Subject: M/45/19/DOC - 7 Hadley Close, Middleton-On-Sea

Regarding this scheme the client now wishes to utilise a porous surface for the driveway which will in essence simply self-drain as opposed to constructing a soakaway.

No. 93/16/05 X

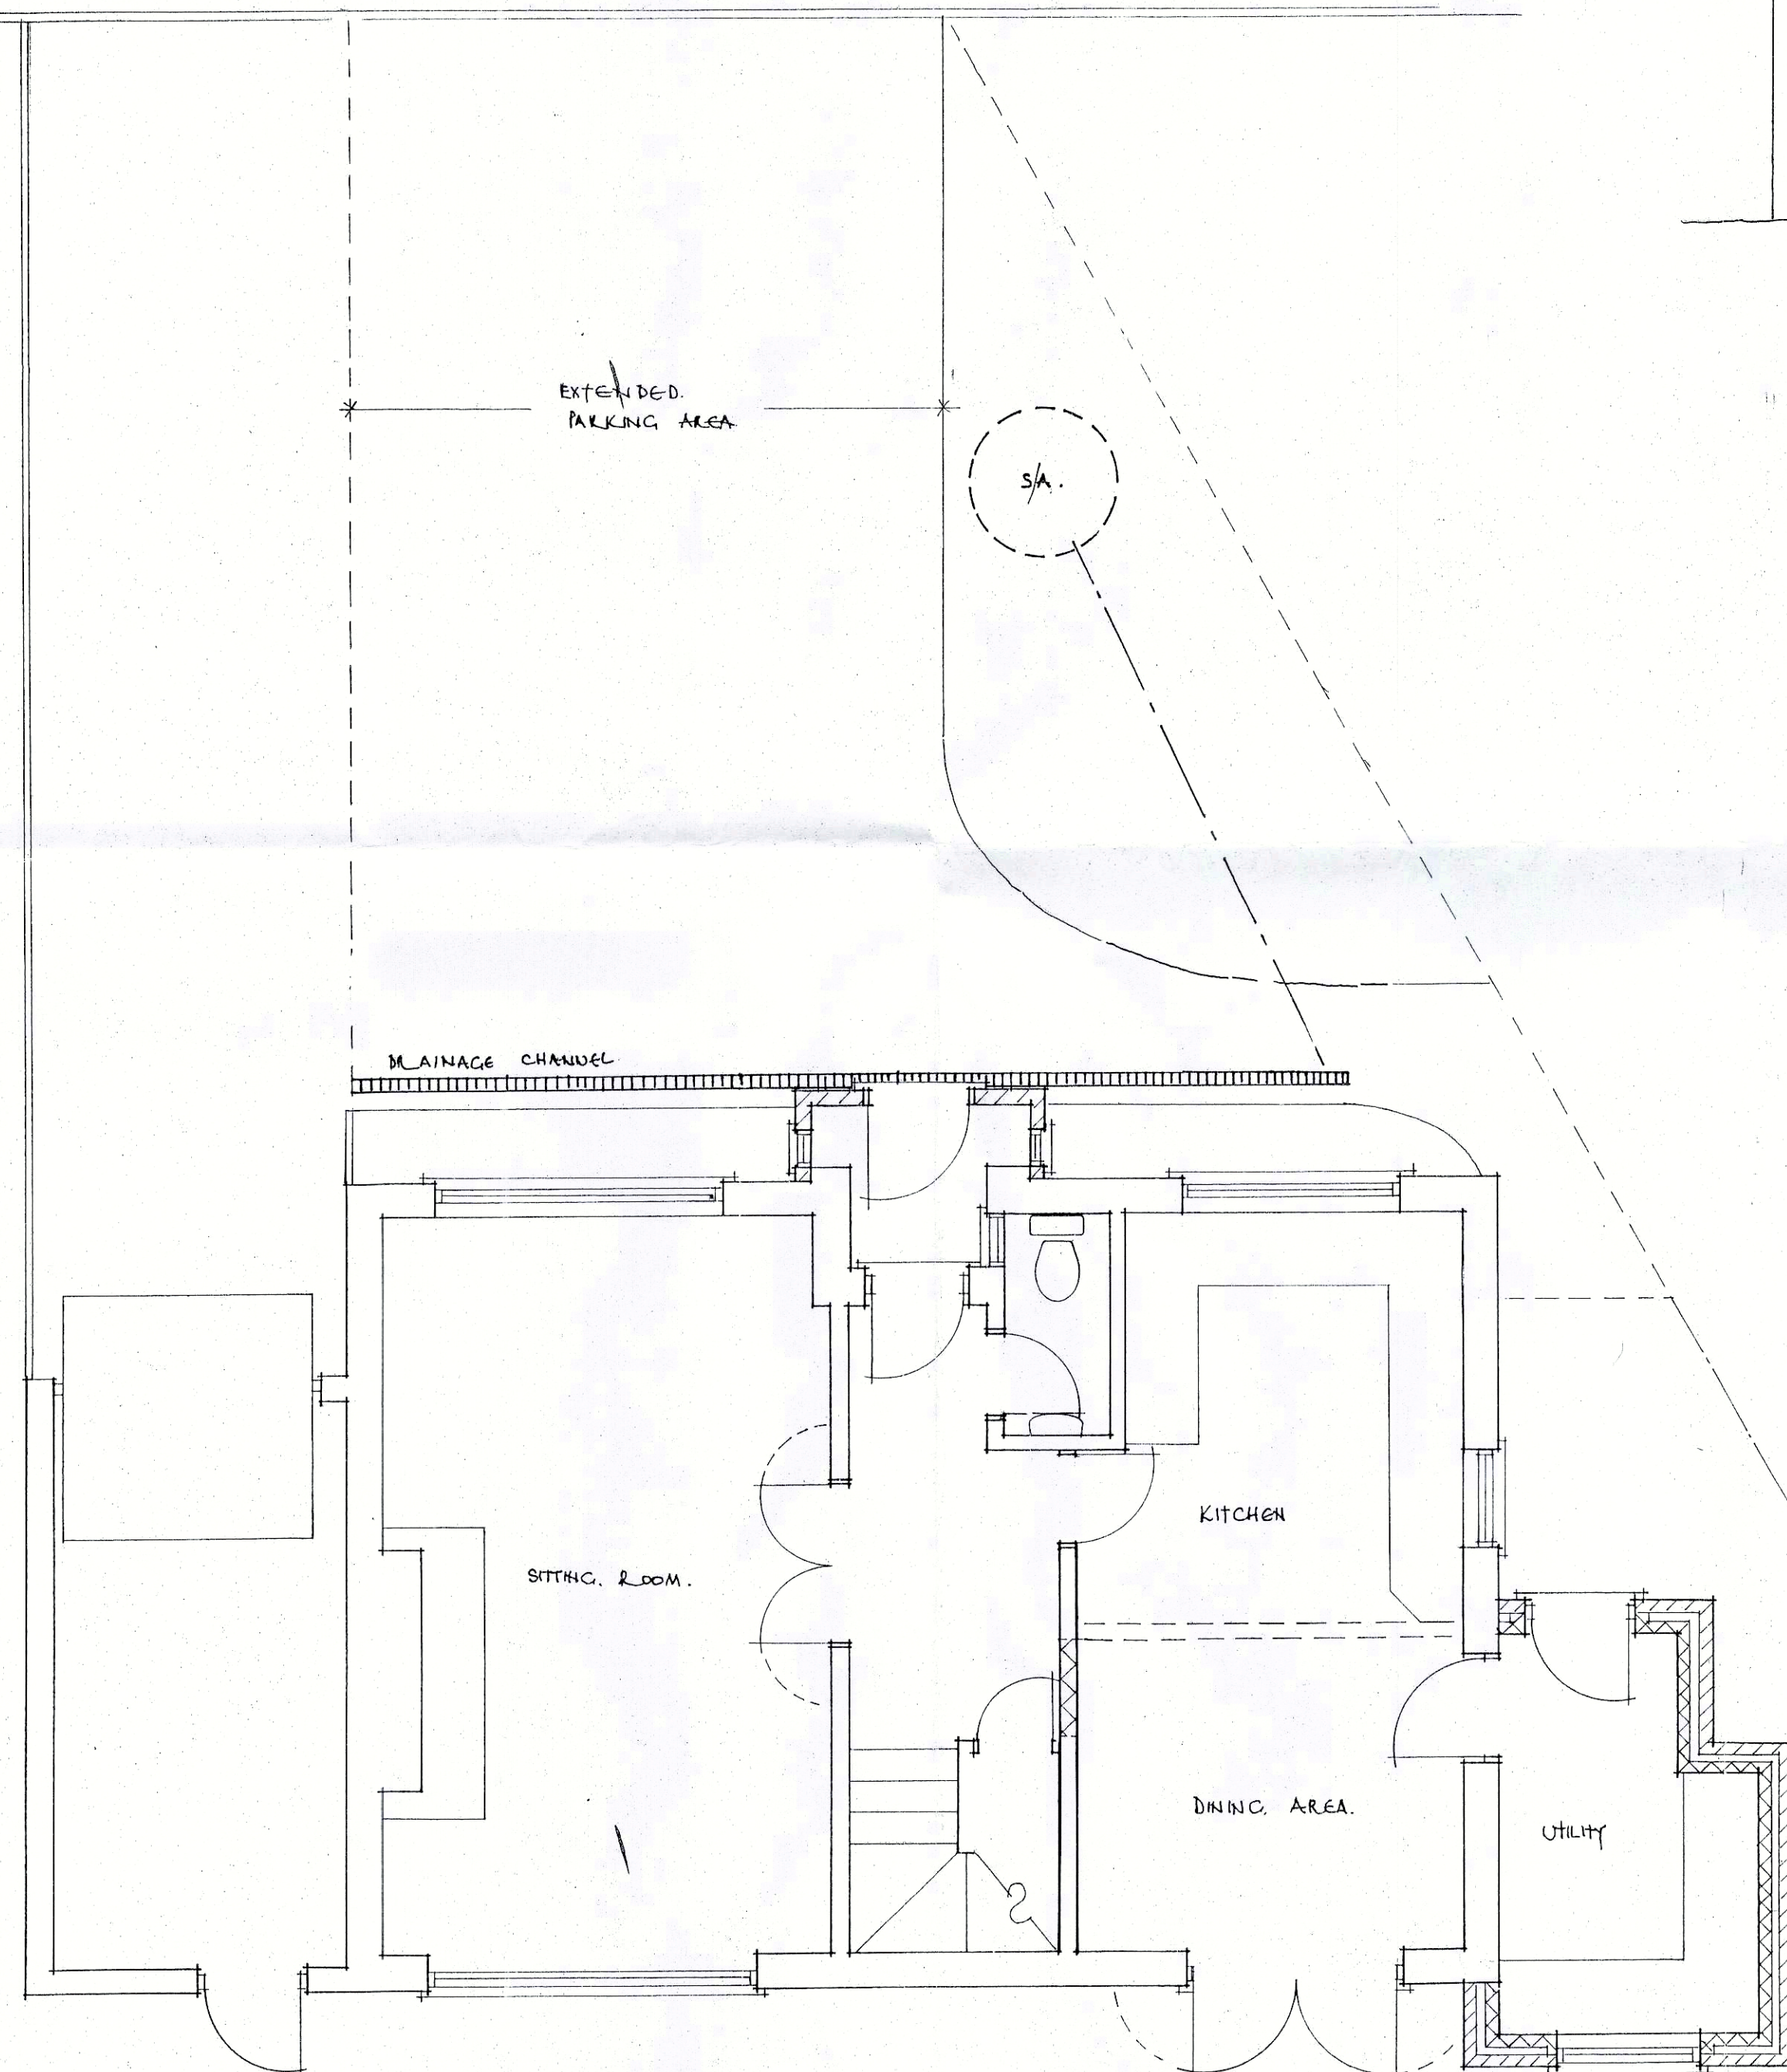
"I have no objection to the applicant using porous paving as opposed to a soakaway. However, they will still need to supply a drainage layout and detail drawings, plus calculations. I am happy for the groundwater to be monitored over a 24 hour period to a depth greater than the proposed paving infiltration structure, but this must be when we expect it to peak in January/February. Similarly the shallow infiltration test will need to be completed at this time."
